Markup Summary

PPR-17-046

1 SITE PLAN
SCALE: 1"=20'-0"

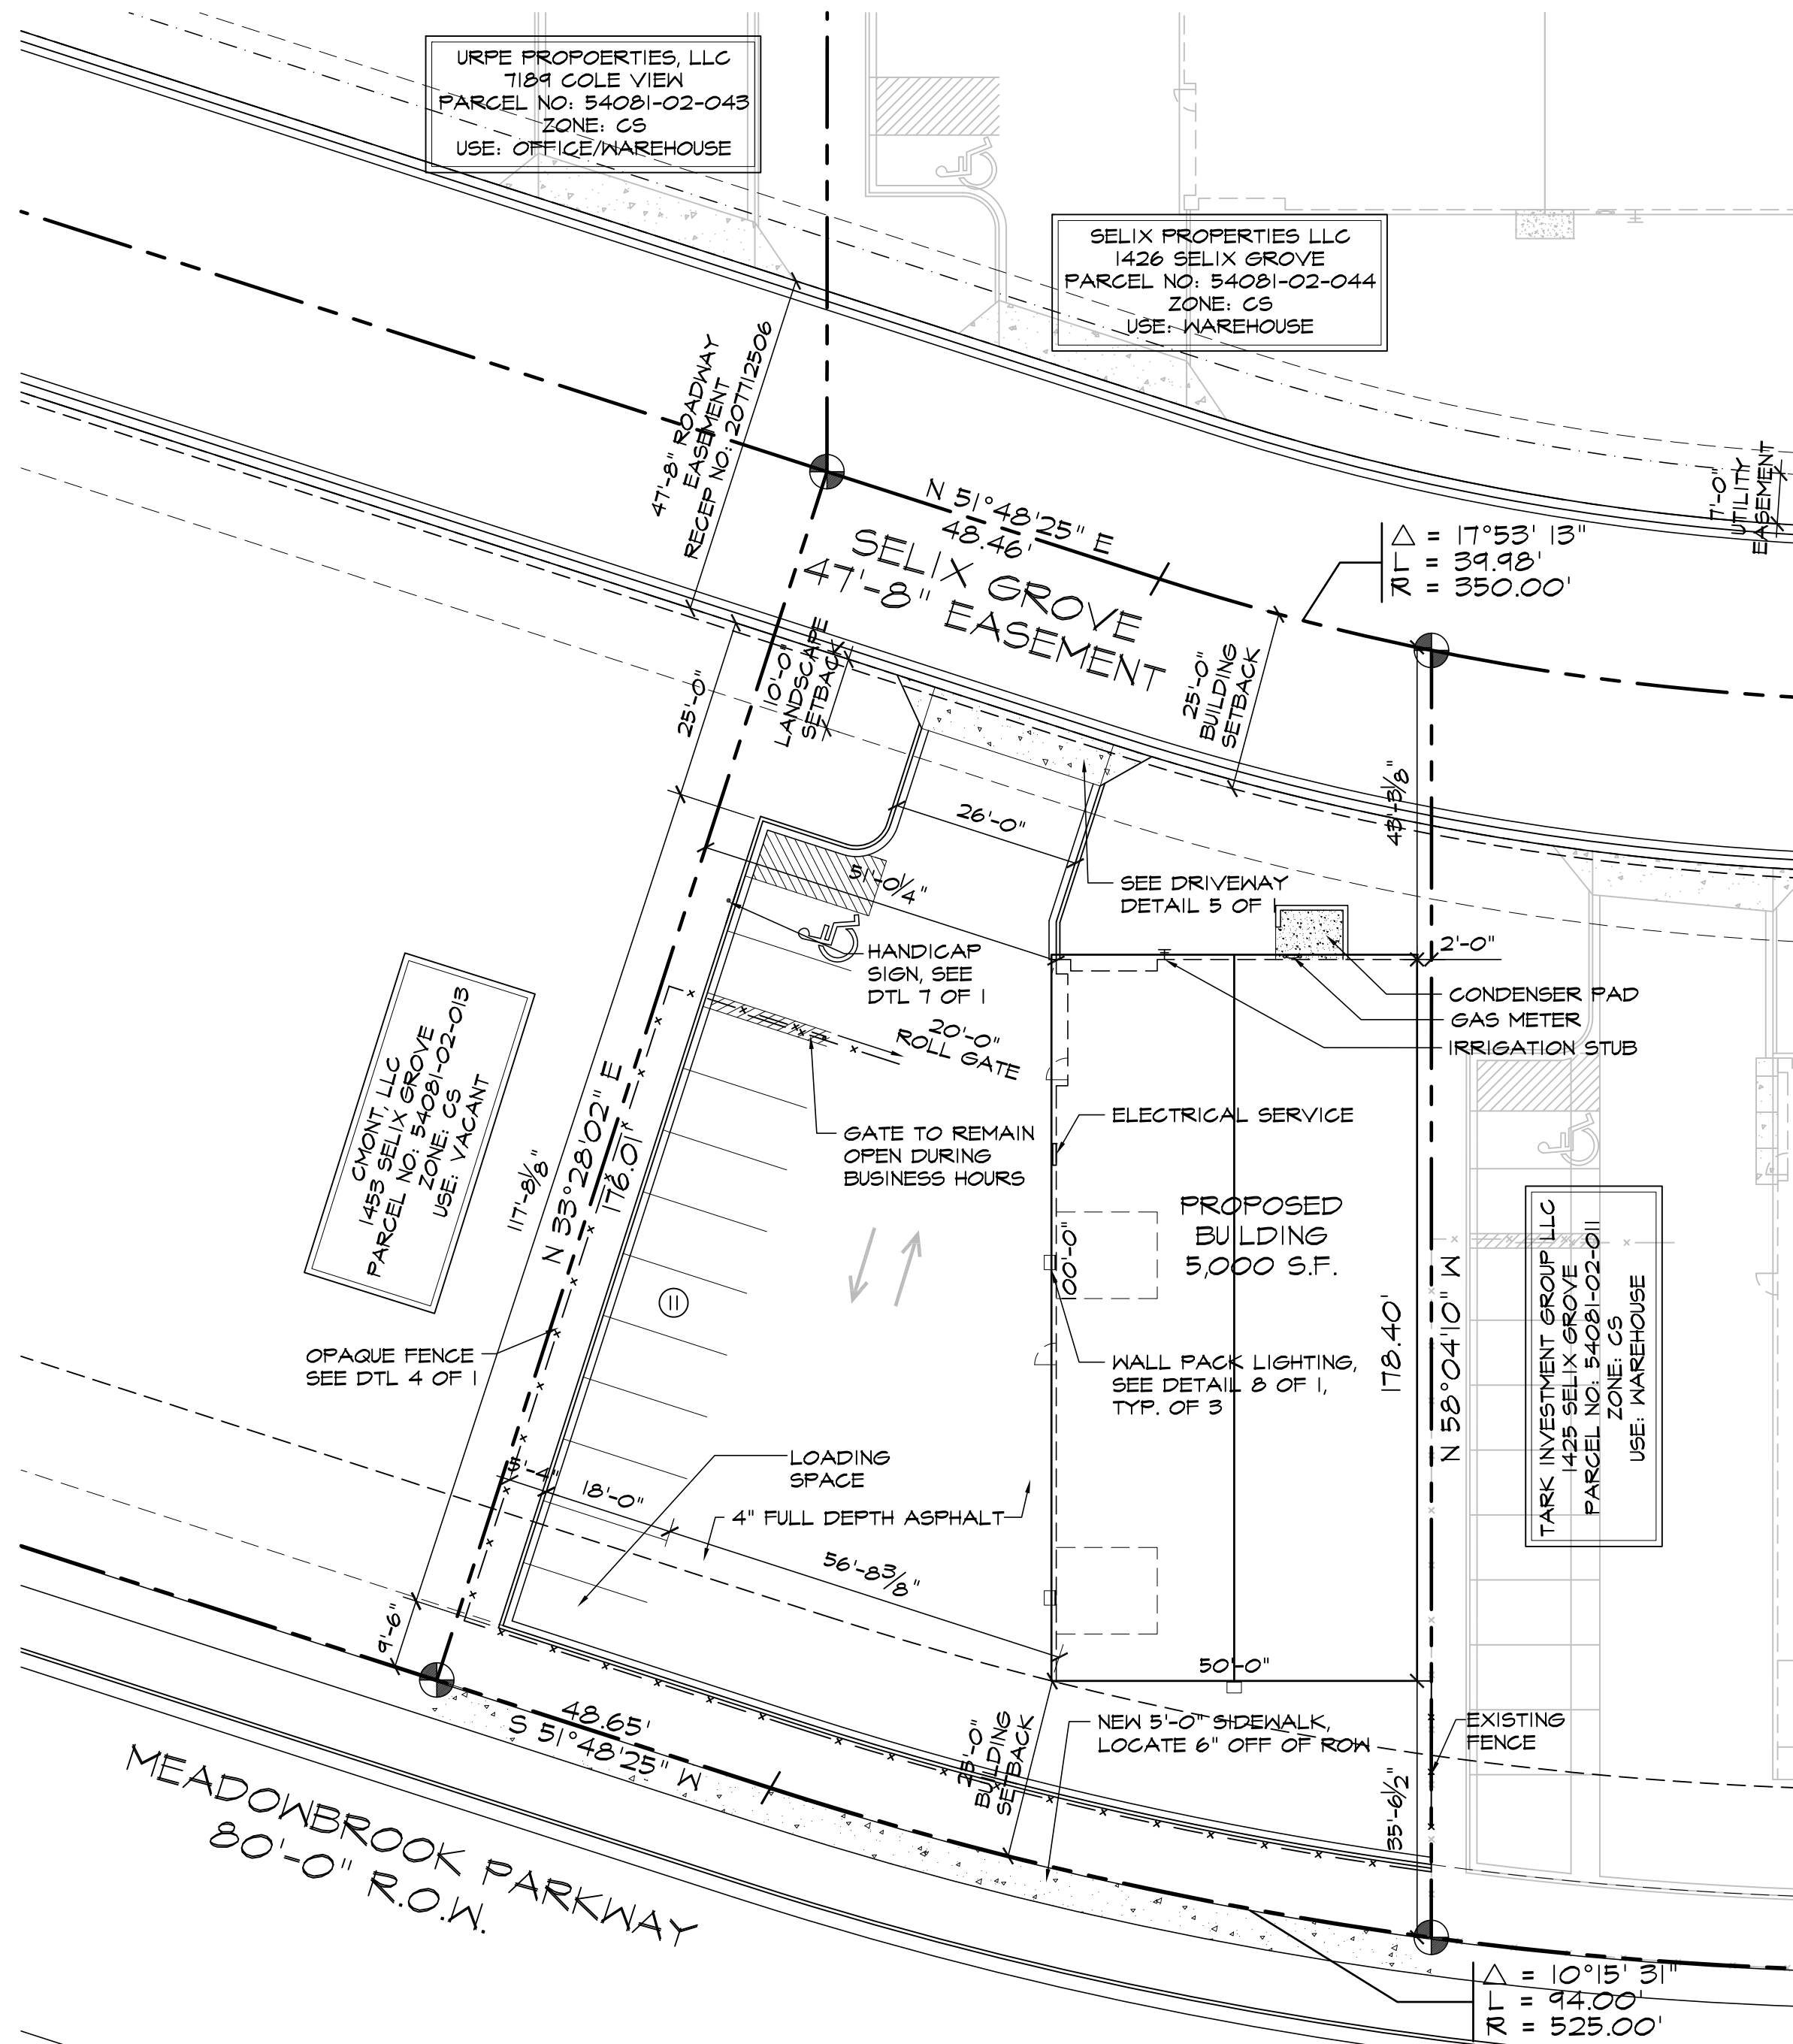
This is a public road. Replace with (Non-Residential Collector)

Revise to 80' ROW.

Show as proposed sidewalk.

Roof drain runoff must be routed into the WQ Facilities and not directly drained onto the street.

Show the Roof Drain Locations

1. Grading on the adjacent property will require permission from the adjacent property owner. Prior to plan approval a verification document from the adjacent property owner is required.

2. The site plan shows there is an existing fence along the property line. Will this be removed and replaced?
